MEMORANDUM

EPC Project No.: PPR2315

Re: Super Star Carwash – Claremont Business Park 2 – Drainage Compliance Letter

C5.2

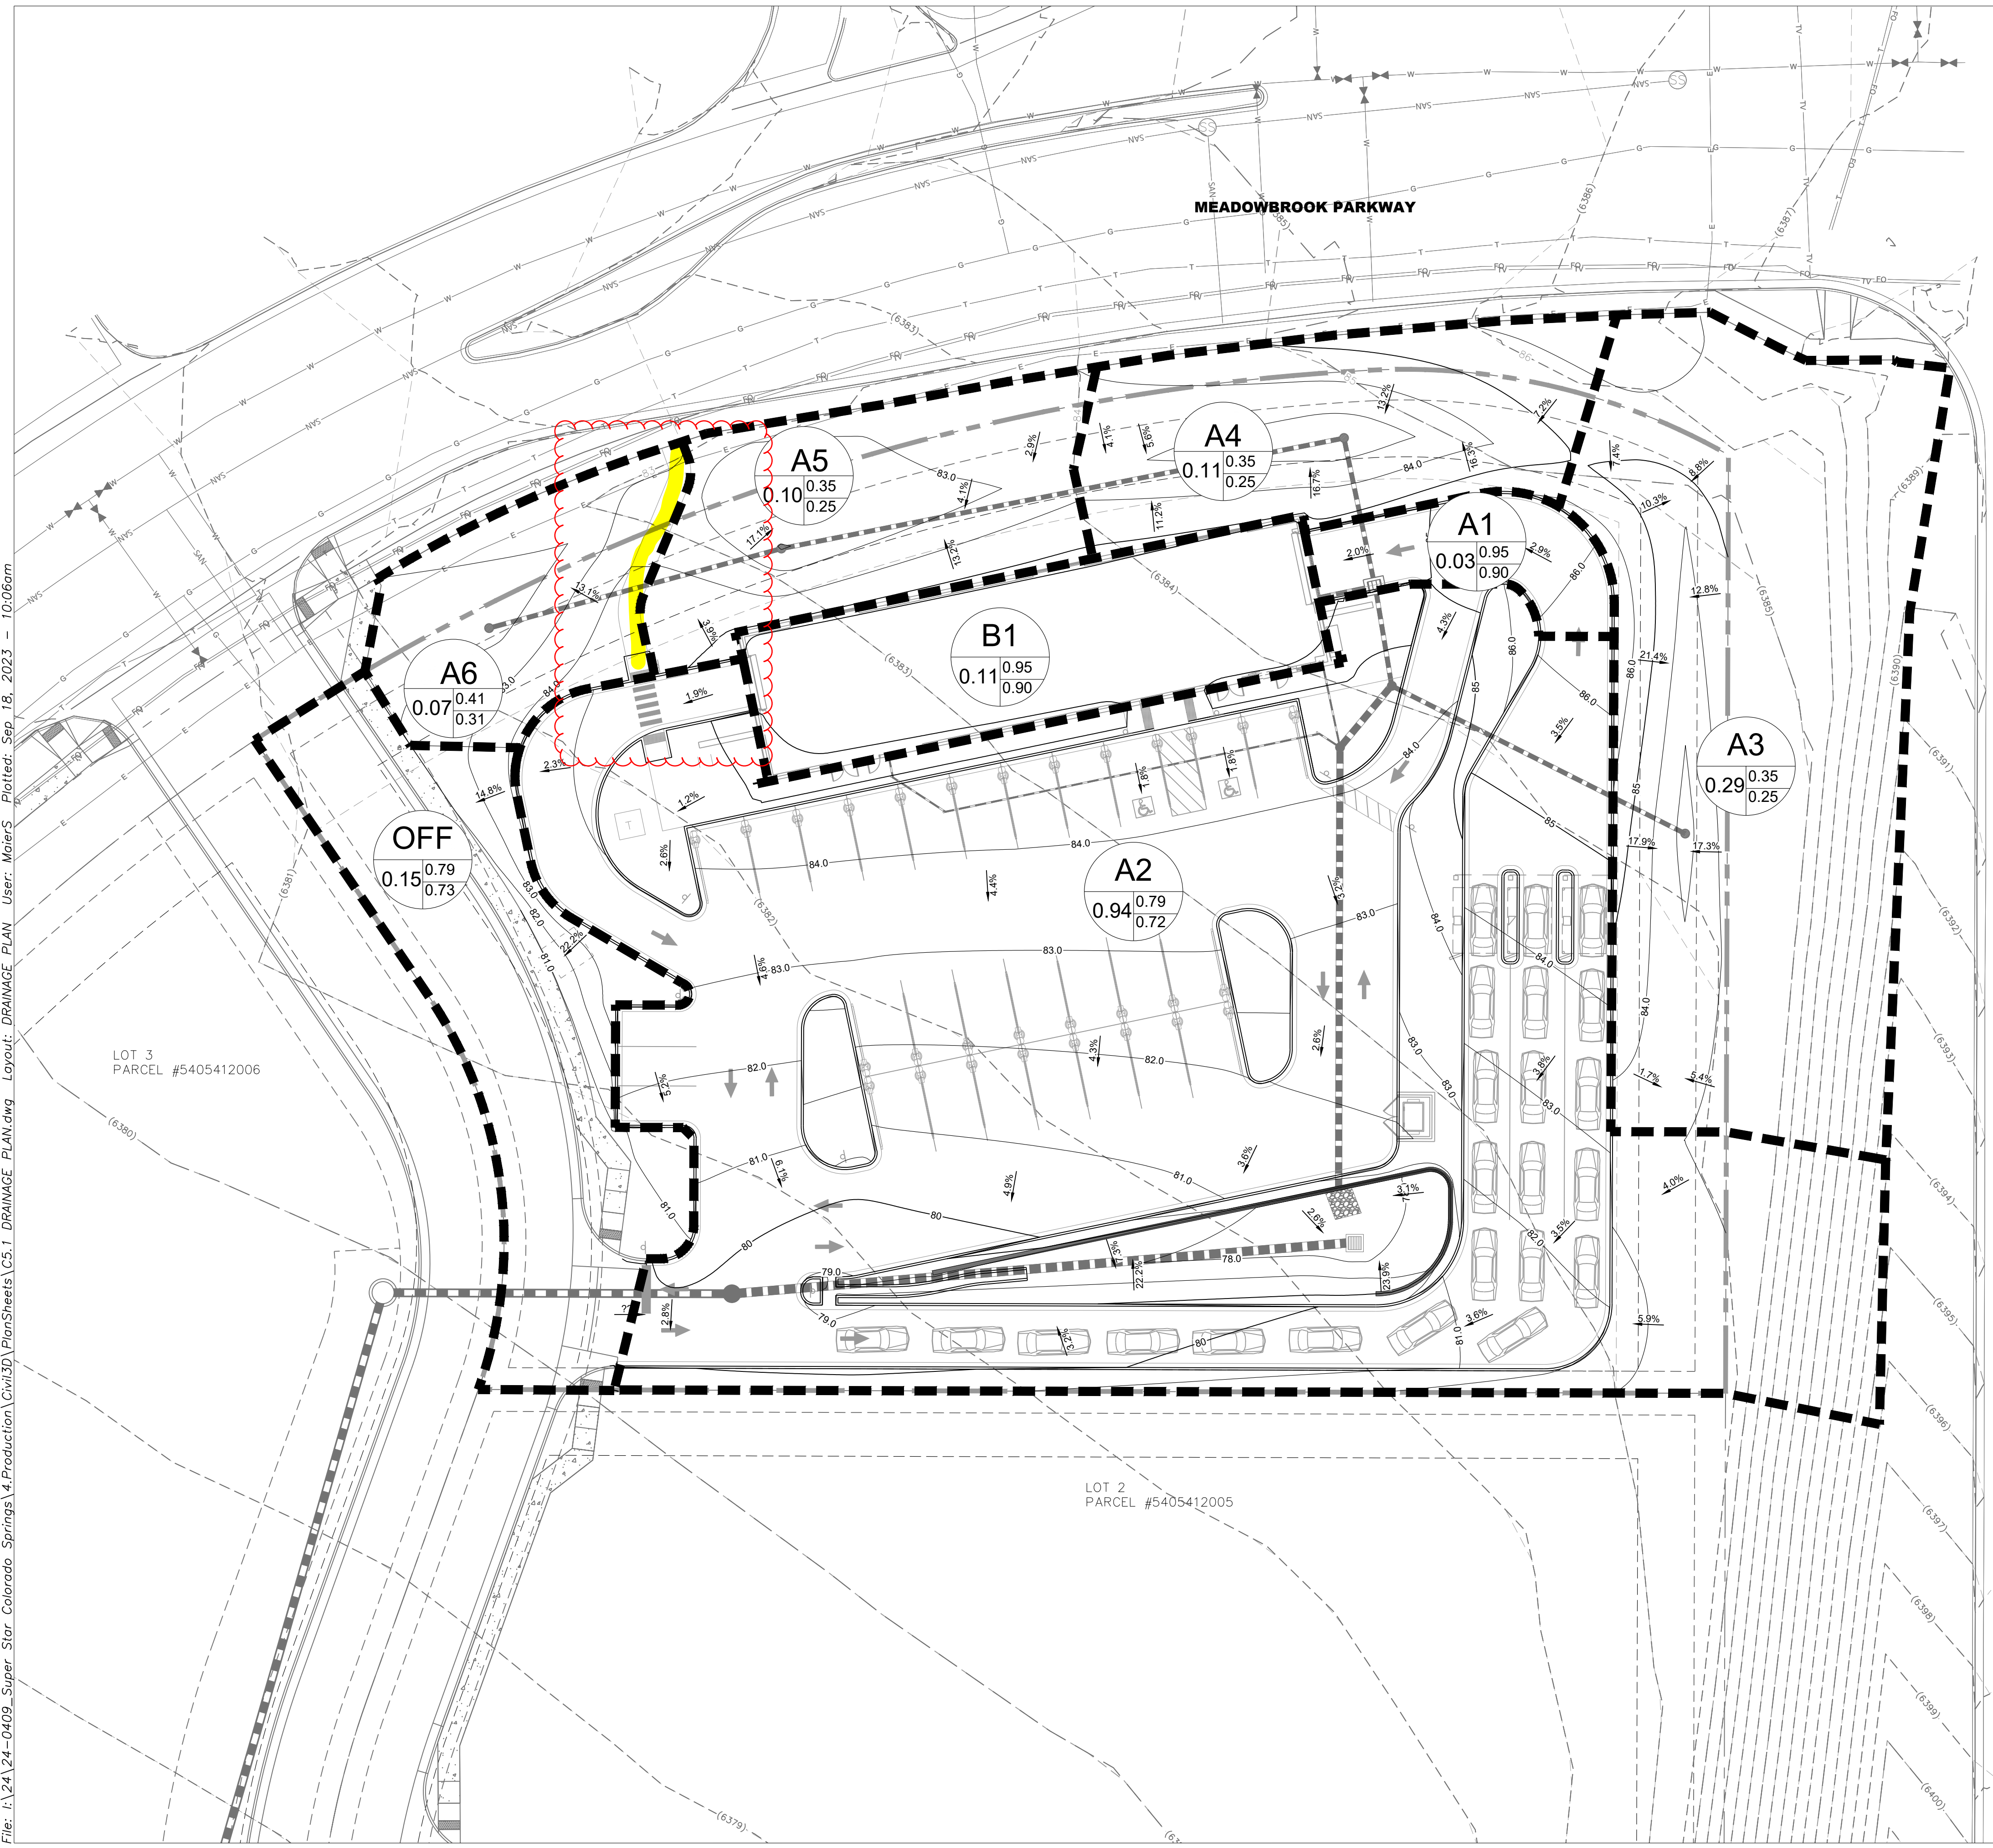
Please add Q Design Point to the drainage map and summary table
Label storm pipe and inlets sizes on the drainage map and the GEC Plan sheets
The drainage report and GEC plan set are approved by the County Engineer so must include those details. They seem to be reflect on the utility plan sheet within the SDP set.

Please label the runoff summary (cfs) and be consistent with the drainage legend as they show 10yr and the runoff summary as 5yr

Unresolved from Submittal 1, 2 - We need to know how much disturbed area is untreated and if there are any exclusions that apply to those areas. So please create a basic overview map (or modify an existing drainage map) with color shading/hatching that shows areas tributary to each PBMP (pond, runoff reduction, etc.) and those disturbed areas that are not treated by a PBMP, with the applicable exclusion labeled (ex: 20% up to 1ac of development can be excluded per ECM App 17.1.C.1 and exclusions listed in ECM App 17.1.B.#). An accompanying summary table on this map would also be very helpful (example provided):

This watershed has proposed landscaping/grading. 20% up to 1ac of development can be excluded per ECM App 17.1.C.1. State in the text and on this exhibit that this area is covered under that exclusion since it does not drain to the rain garden.
